Re: EN 010151 - Beacon Fen Energy Park

Boston Borough Council's - Deadline Six Submission – 12th January 2026.

The letter sets out Boston Borough Council (BBC) response to the Applicants Deadline 5 submissions for the above Project.

N:\ST\ST19595 - SOLAR PV DCO BICKER FEN\03 - DESIGN\AUTOCAD\ST19595-082- LANDSCAPE STRATEGY PLAN (DRAWINGS FOR EP REV17 ETC) WITH BA BUNDLING

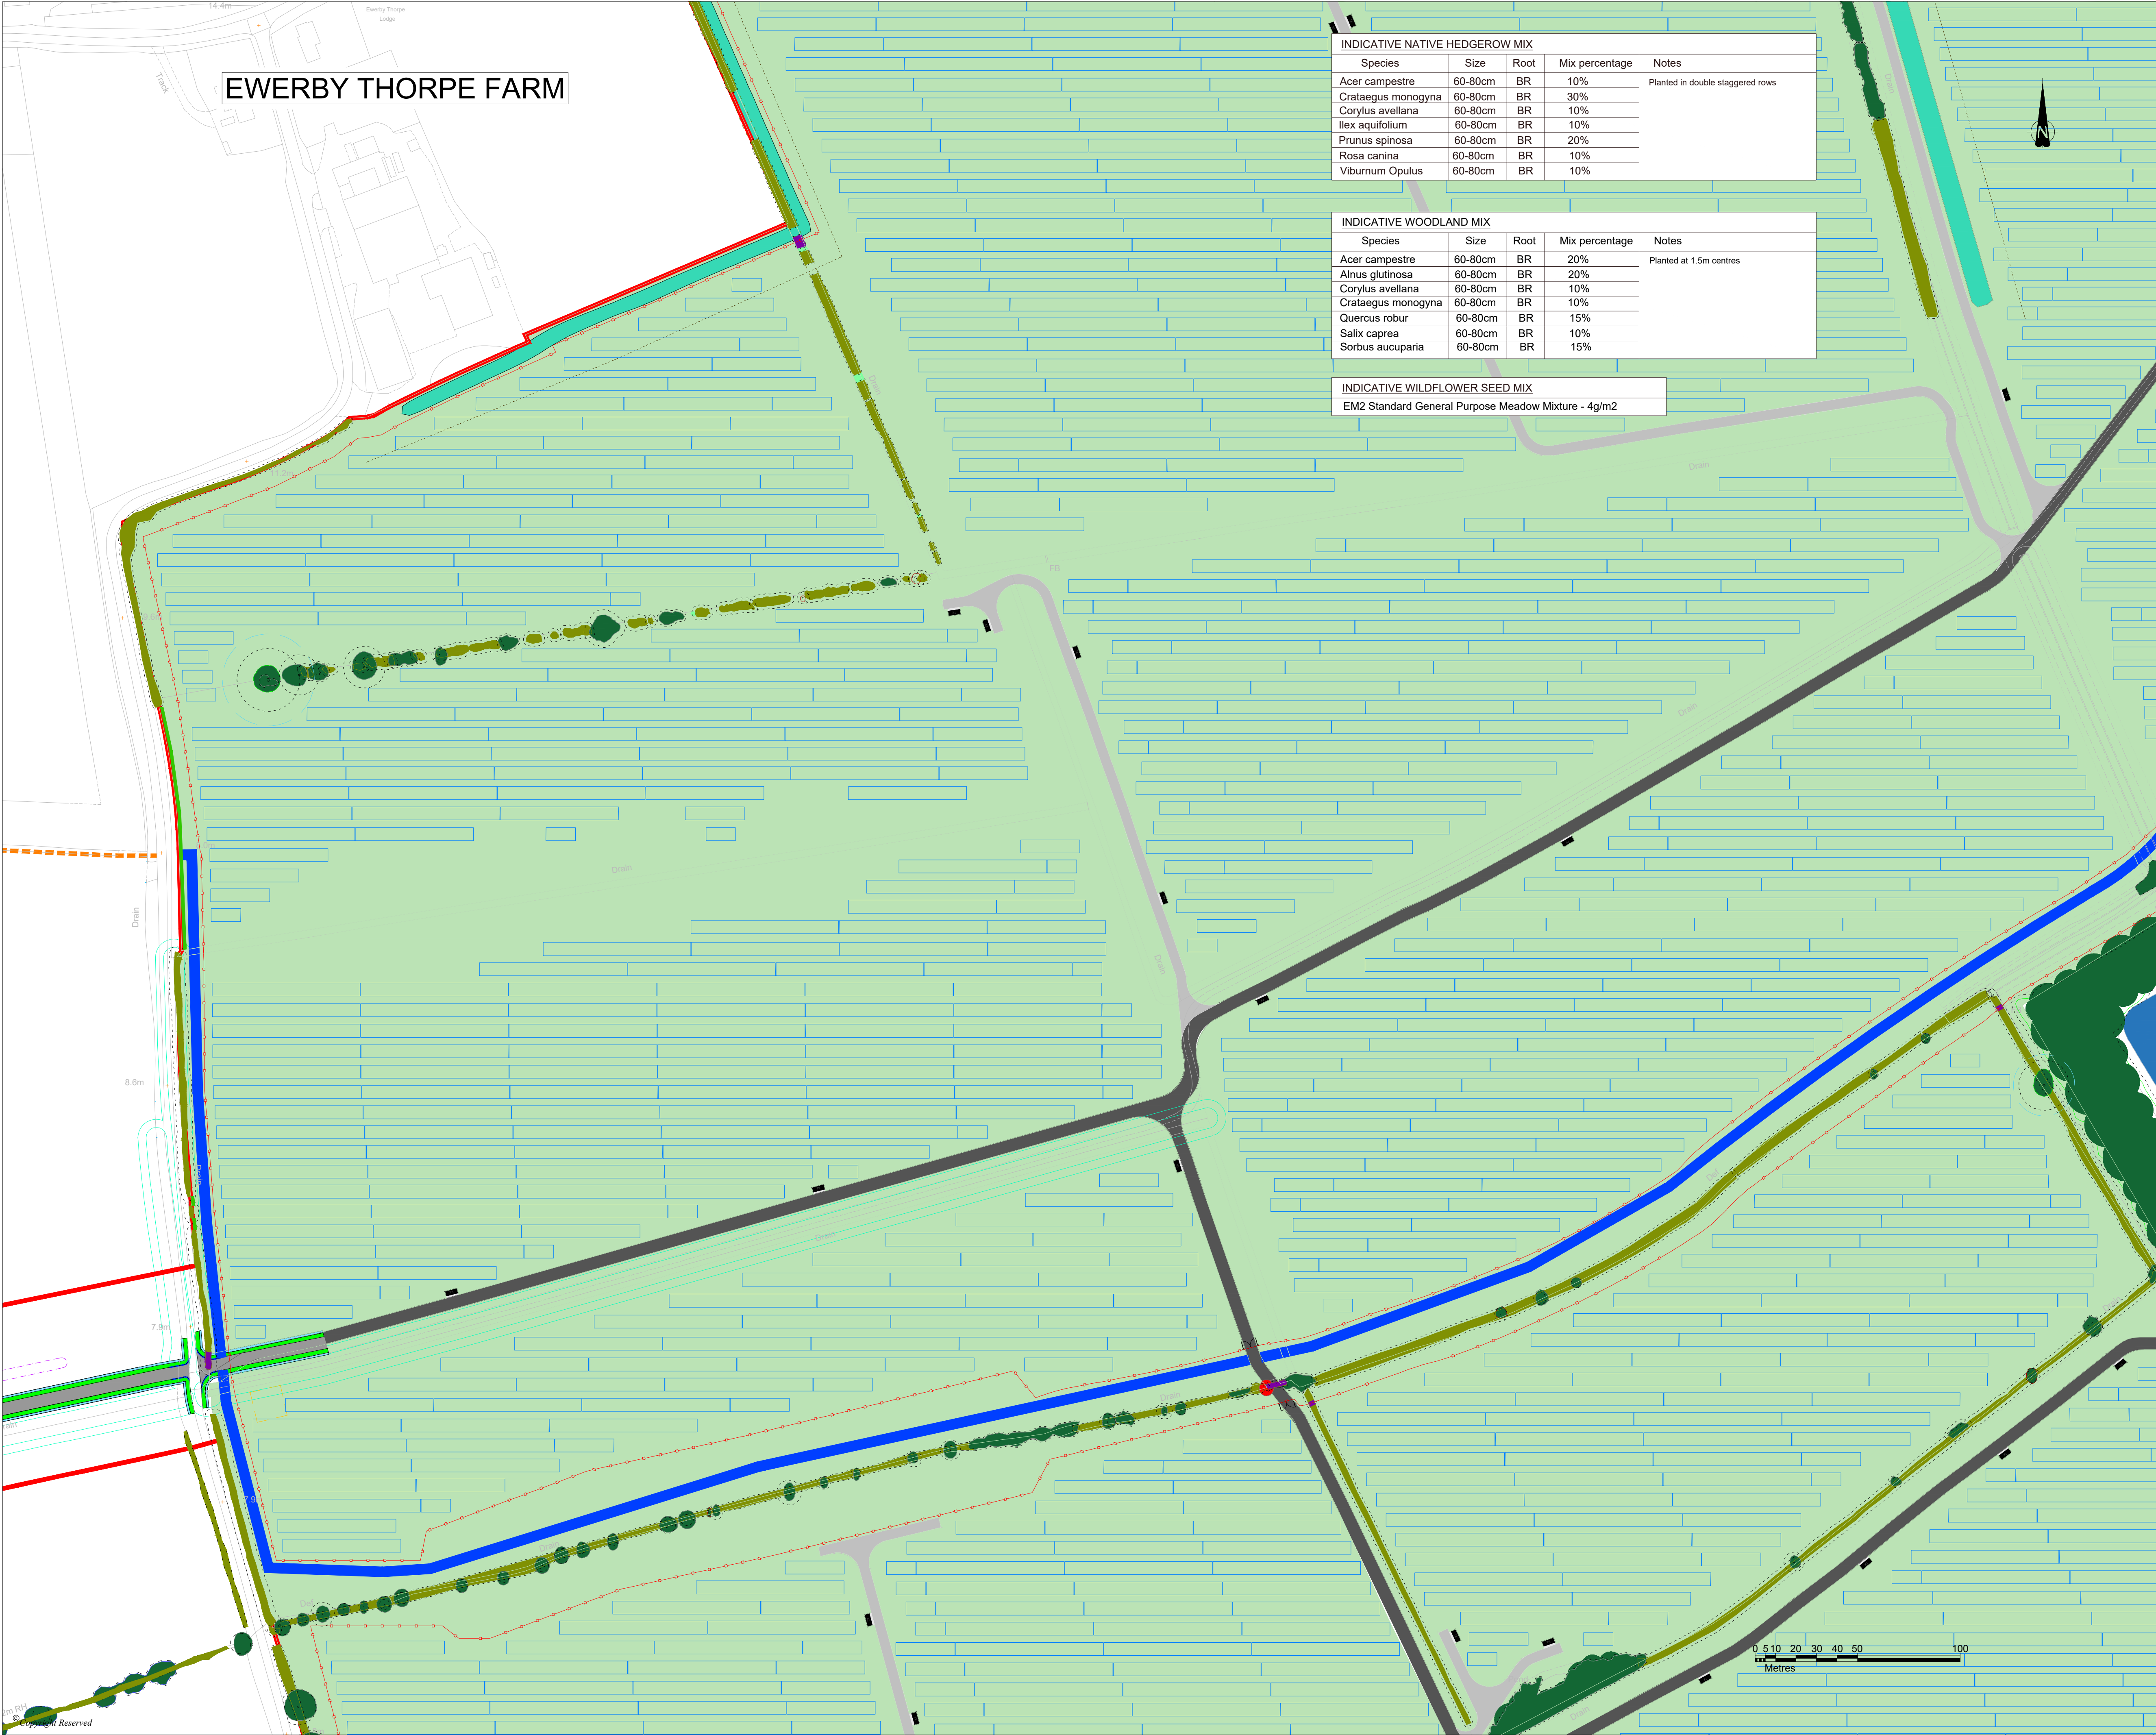
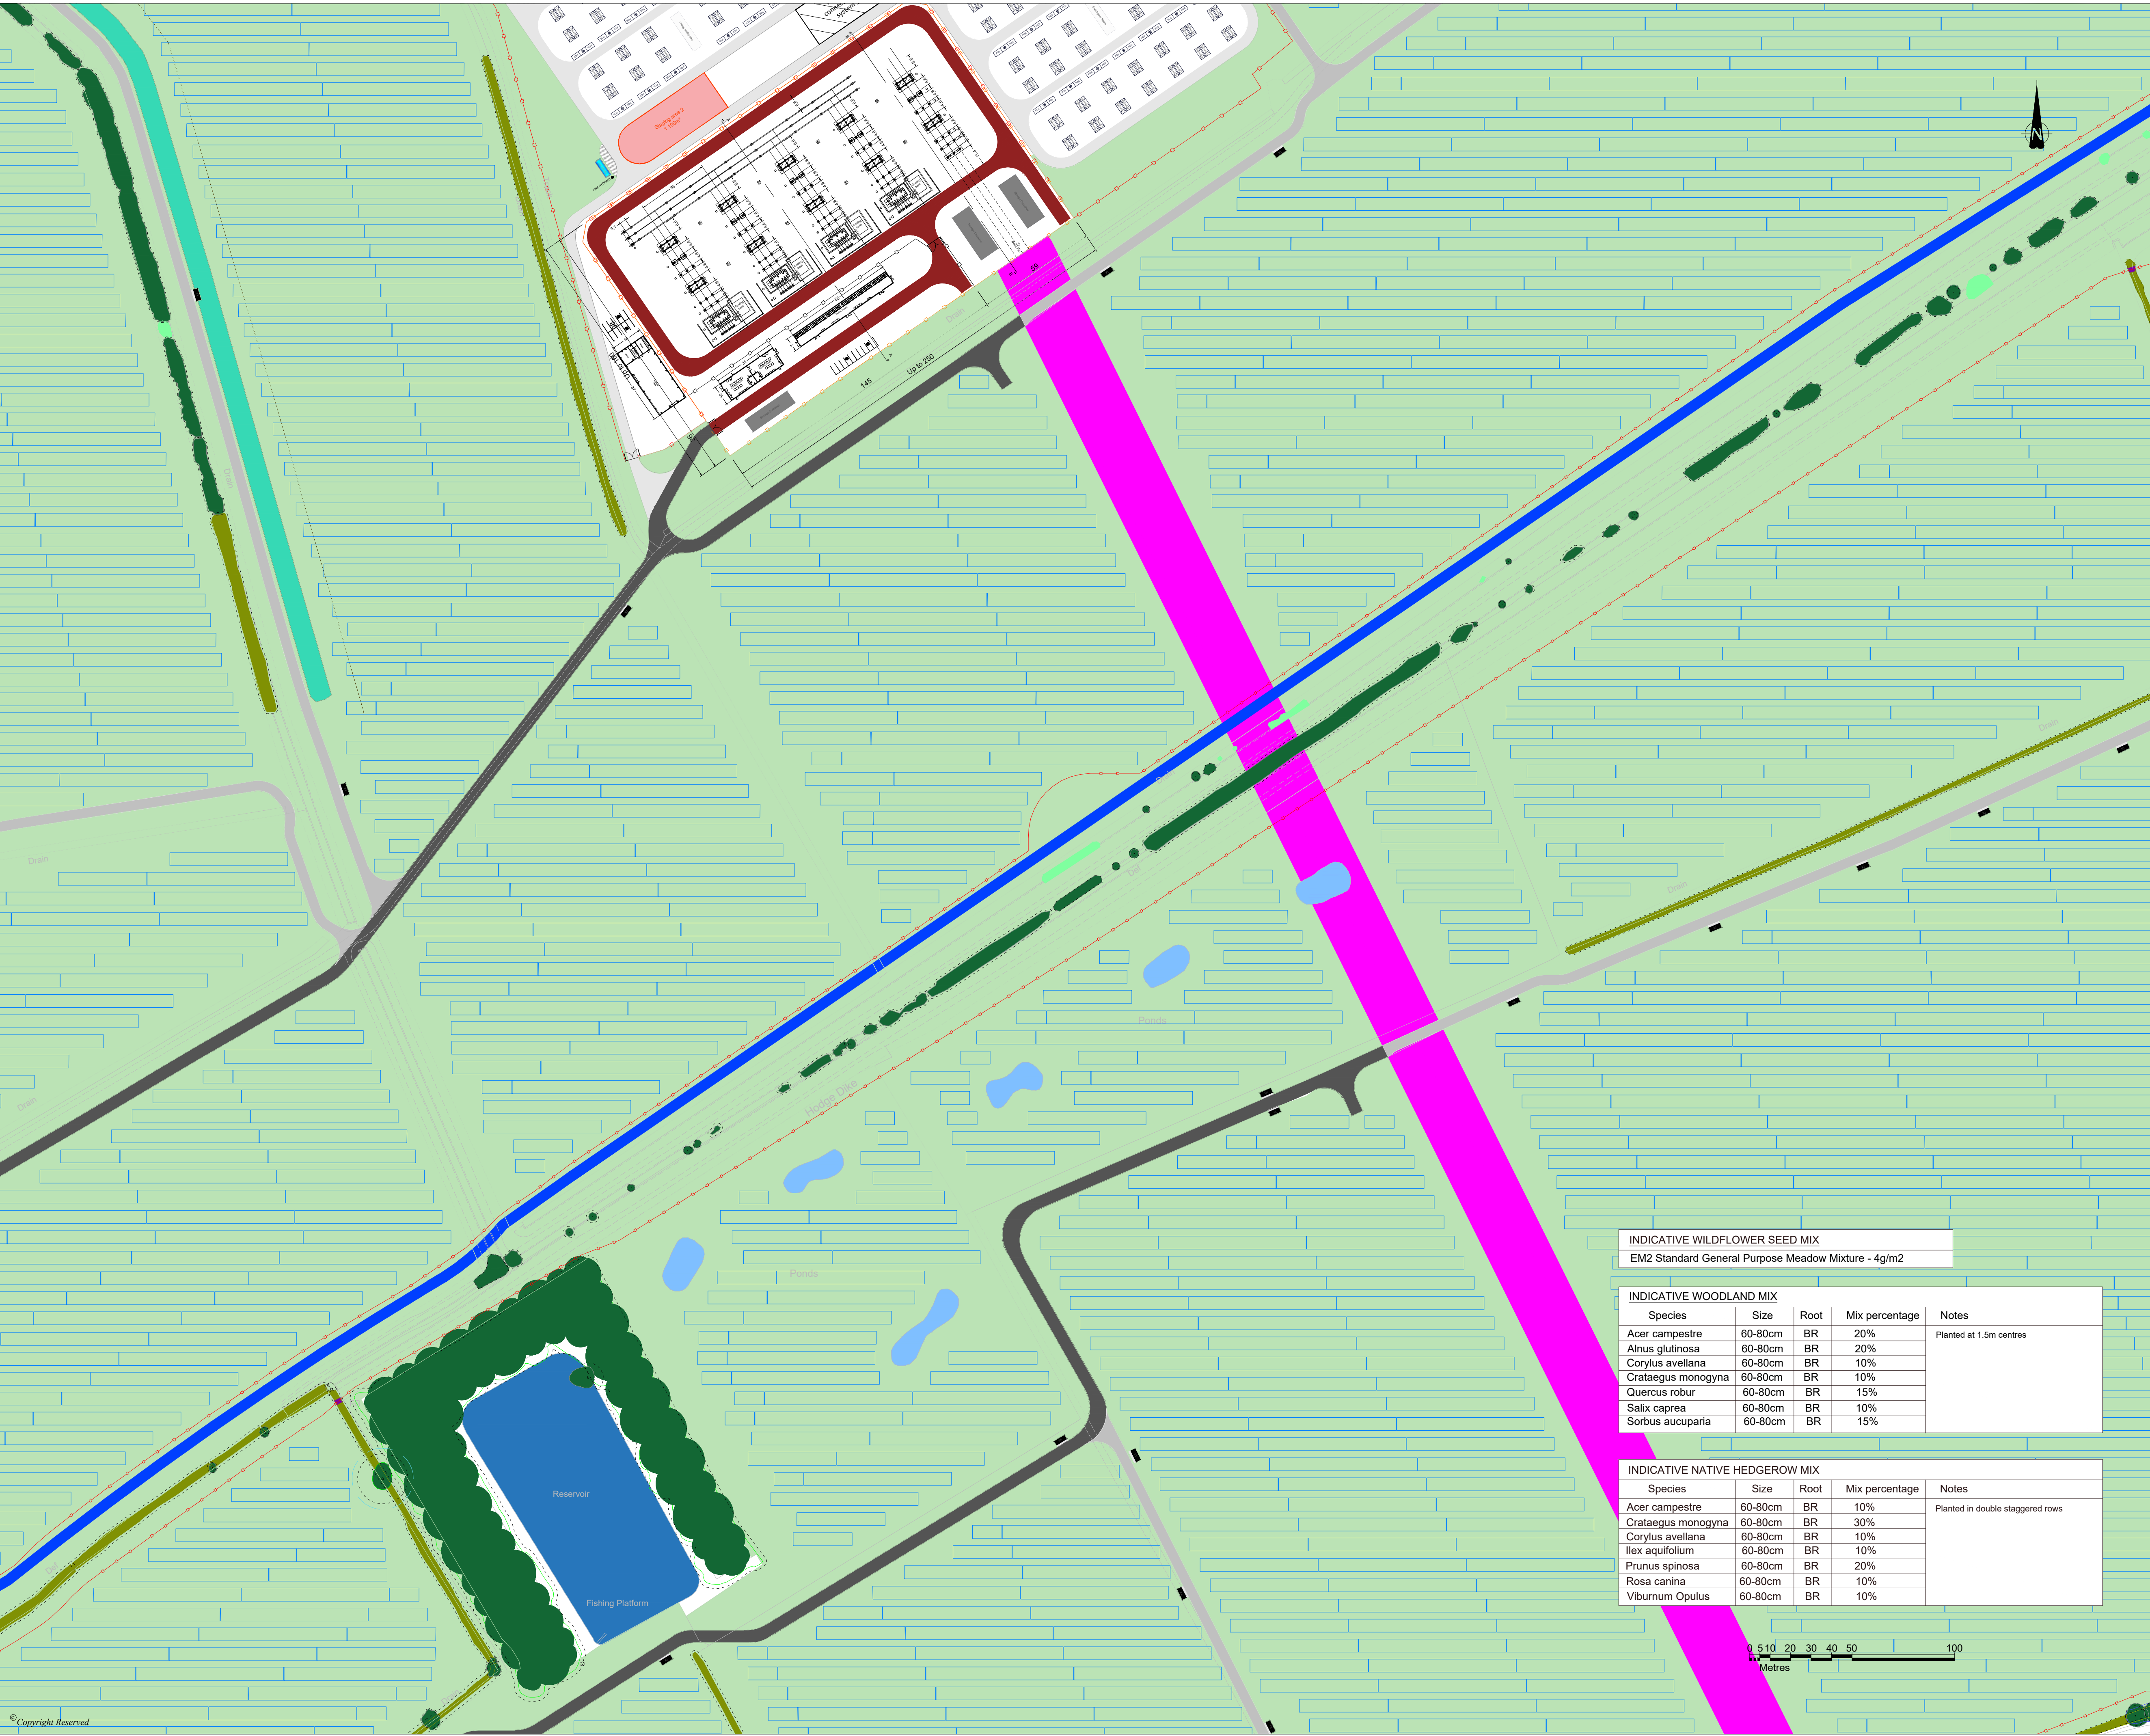
The Landscape Enhancement Measures included within the Change Request OLEMP (CR-016) and Change Request Landscape Strategy Plans (CR-021) at the existing Bicker Fen Substation are not included within the D5 OLEMP (REP5-026). BBC therefore requests that the OLEMP is updated to avoid confusion and understands that the Applicant will submit an updated OLEMP.

The Landscape Strategy Plan also references areas where vegetation is to be temporarily removed or temporarily lain to aggregate and, in both cases, reinstated. There is also reference to a restoration plan.
